CITY OF ALBUQUERQUE

June 13, 2016

Re: TEF Warehouse
10116 Cochiti Rd. NE
Traffic Circulation Layout
Engineer's/Architect's Stamp **6-9-16** (L20-D069)

**TRAFFIC CIRCULATION LAYOUT PLAN**

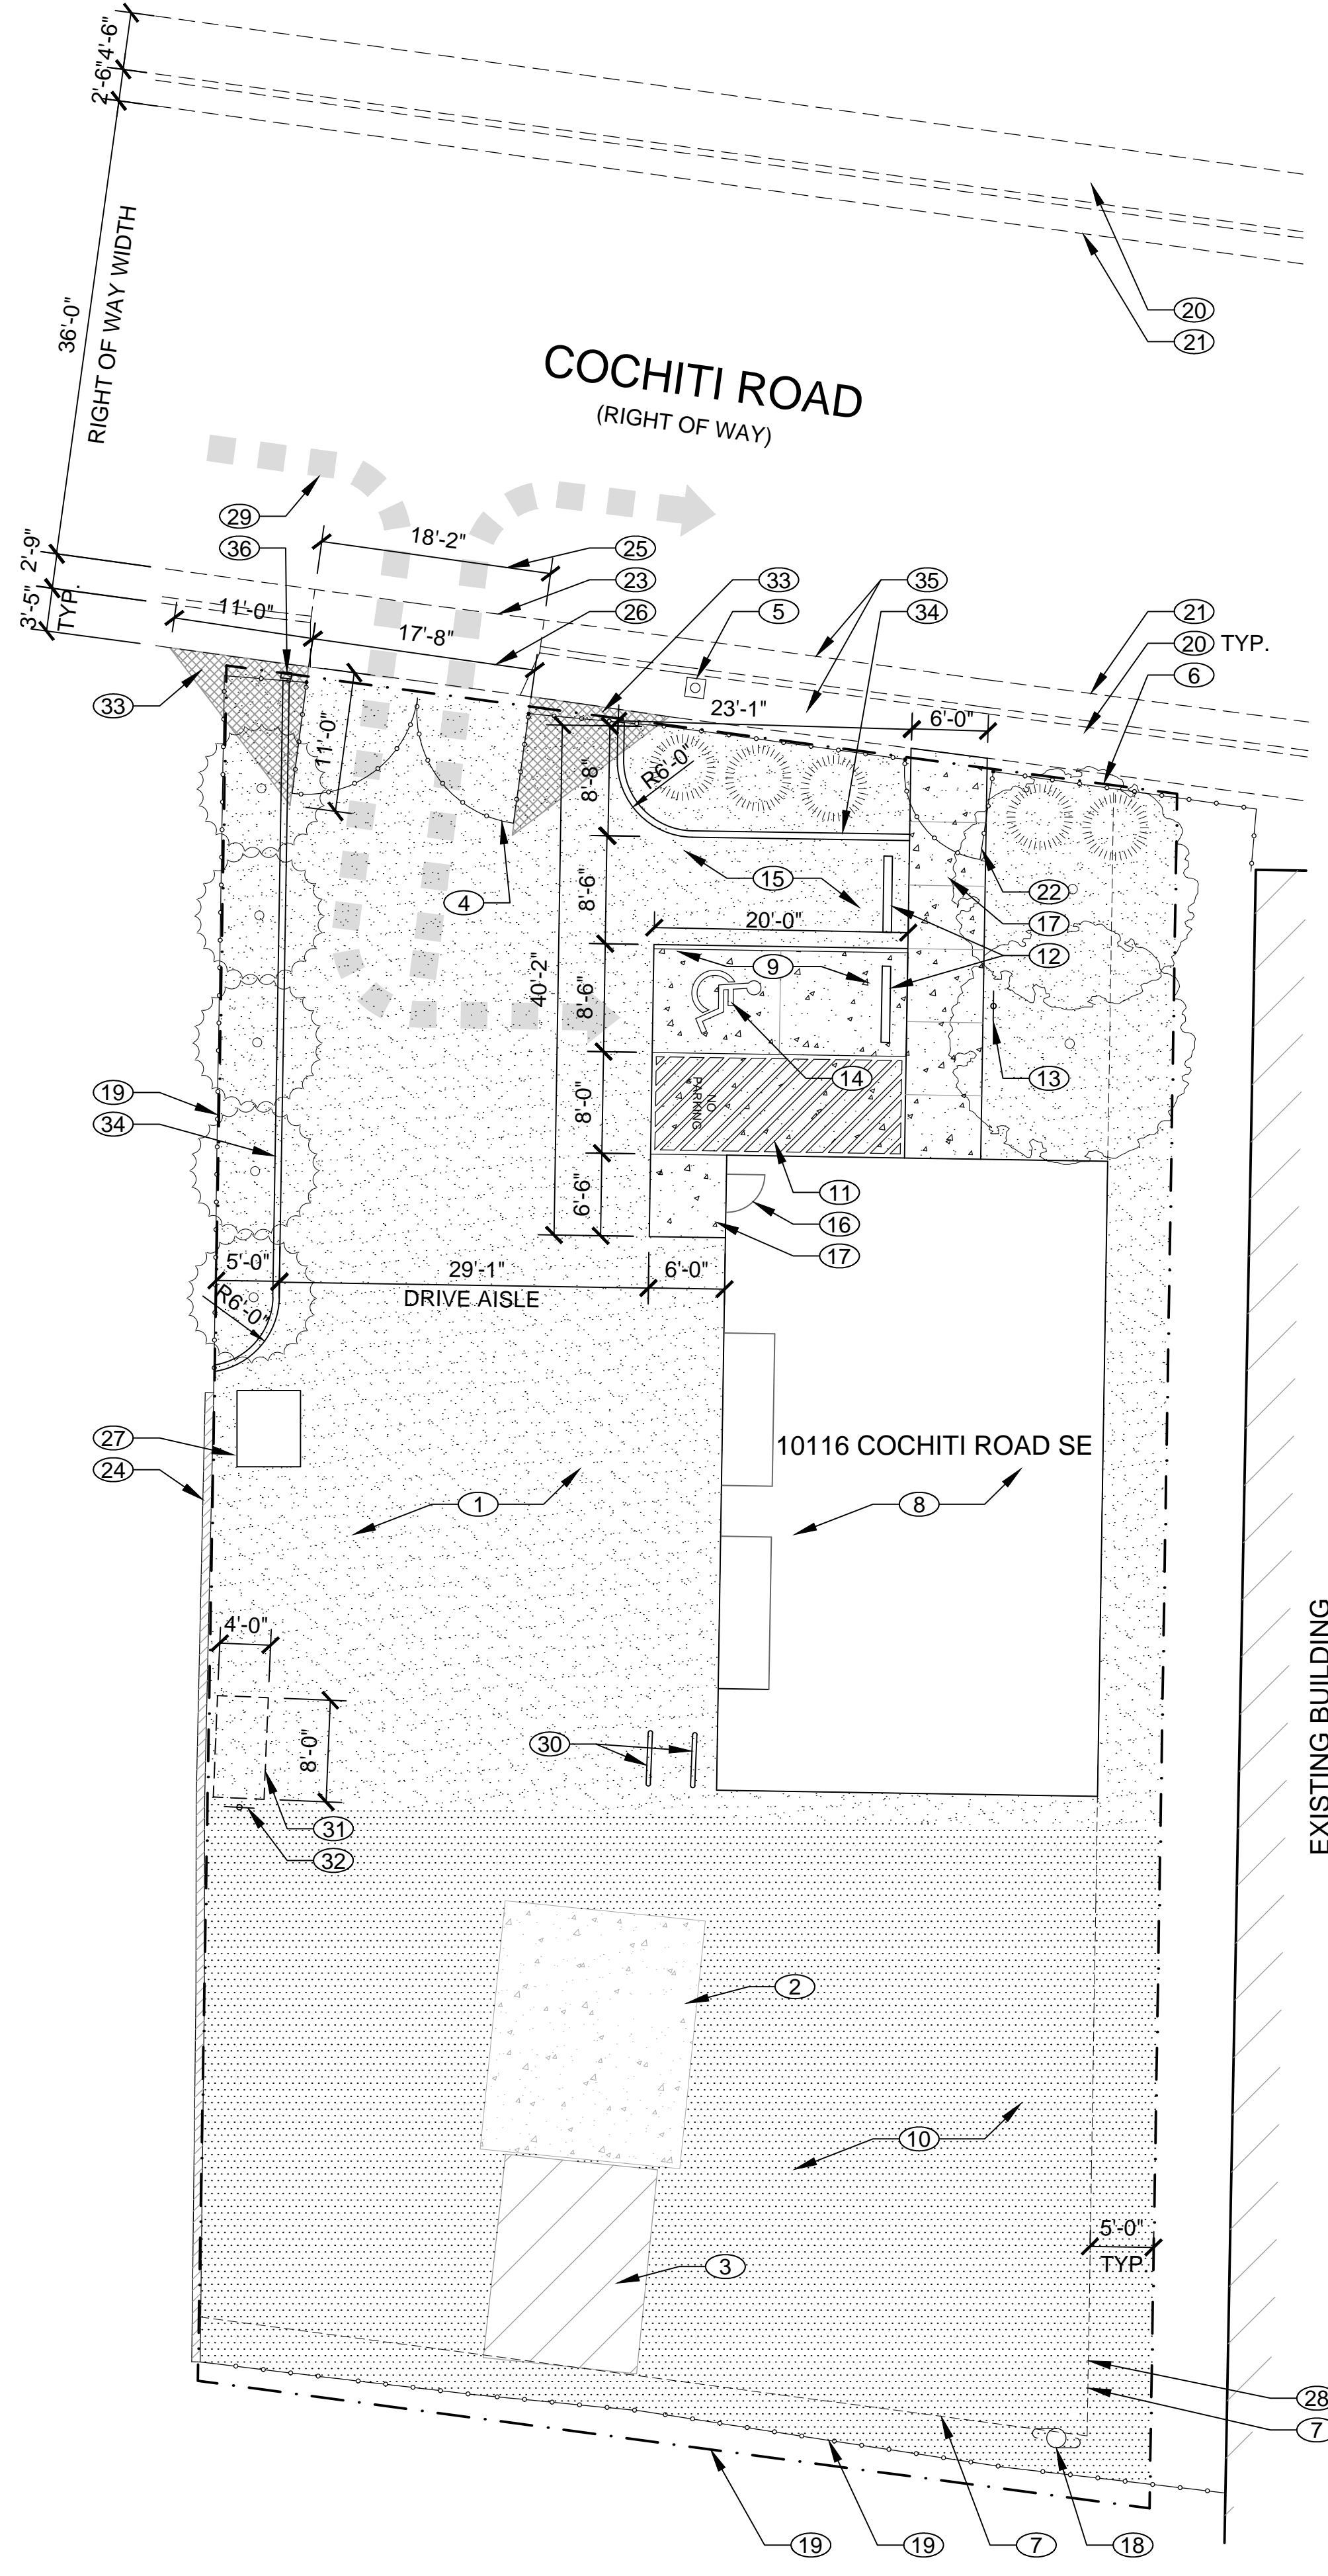
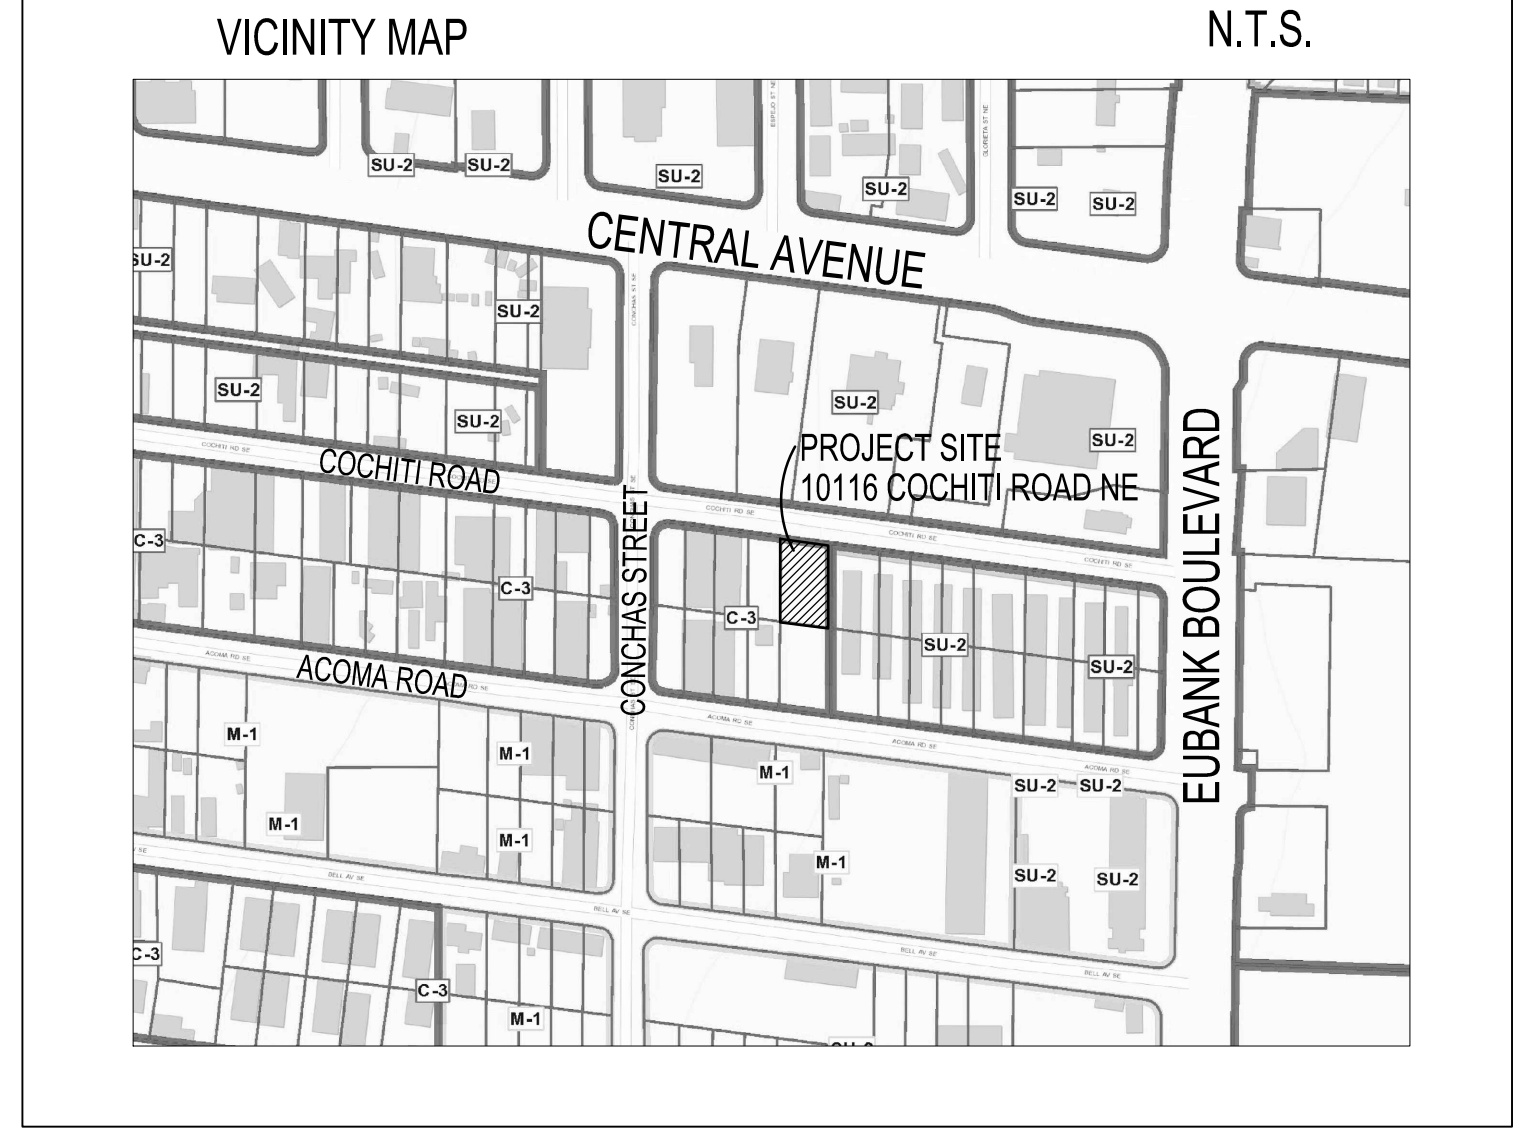
1. The handicap accessible spaces must include an 8 ft. wide van access aisle; all other aisles should be 5 ft. in width.
2. Show all drive aisle widths and radii.

3. List radii for all curves shown; for passenger vehicles, the minimum end island radius is 15 ft. Landscape island radius for delivery trucks, fire trucks, etc. is 25 ft. or larger.

4. Per DPM, a 6 ft. wide ADA accessible pedestrian pathway is required from the HC parking stall access aisles to the building entrances. Please clearly show this pathway and provide details. In review of the submitted drawing, a 5 ft. access aisle is detailed.

5. Provide a min 6" or max 8" high concrete barrier curb or other acceptable barrier between landscaping and parking areas and/or drive aisles. Please call out detail and location of barrier curb.

6. Design delivery vehicle route needs to be shown.
7. Service vehicle and/or refuse vehicle maneuvering must be contained on-site; provide a copy of refuse approval.

8. Please provide a sight distance exhibit (see the *Development Process Manual, Chapter 23, Section 3*). Please show this detail for the entrance/exit on Cochiti Rd.

9. Please add the following note to the clear sight triangle: "Landscaping and signage will not interfere with clear sight requirements. Therefore, signs, walls, trees, and shrubbery between 3 and 8 feet tall (as measured from the gutter pan) will not be acceptable in this area."
10. Unused curb cuts must be replaced with sidewalk and curb & gutter. A build note must be provided referring to the appropriate City Standard drawing.
11. All broken or cracked sidewalk must be replaced with sidewalk and curb & gutter. A build note must be provided referring to the appropriate City Standard drawing.
12. Please include two copies of the traffic circulation layout at the next submittal.
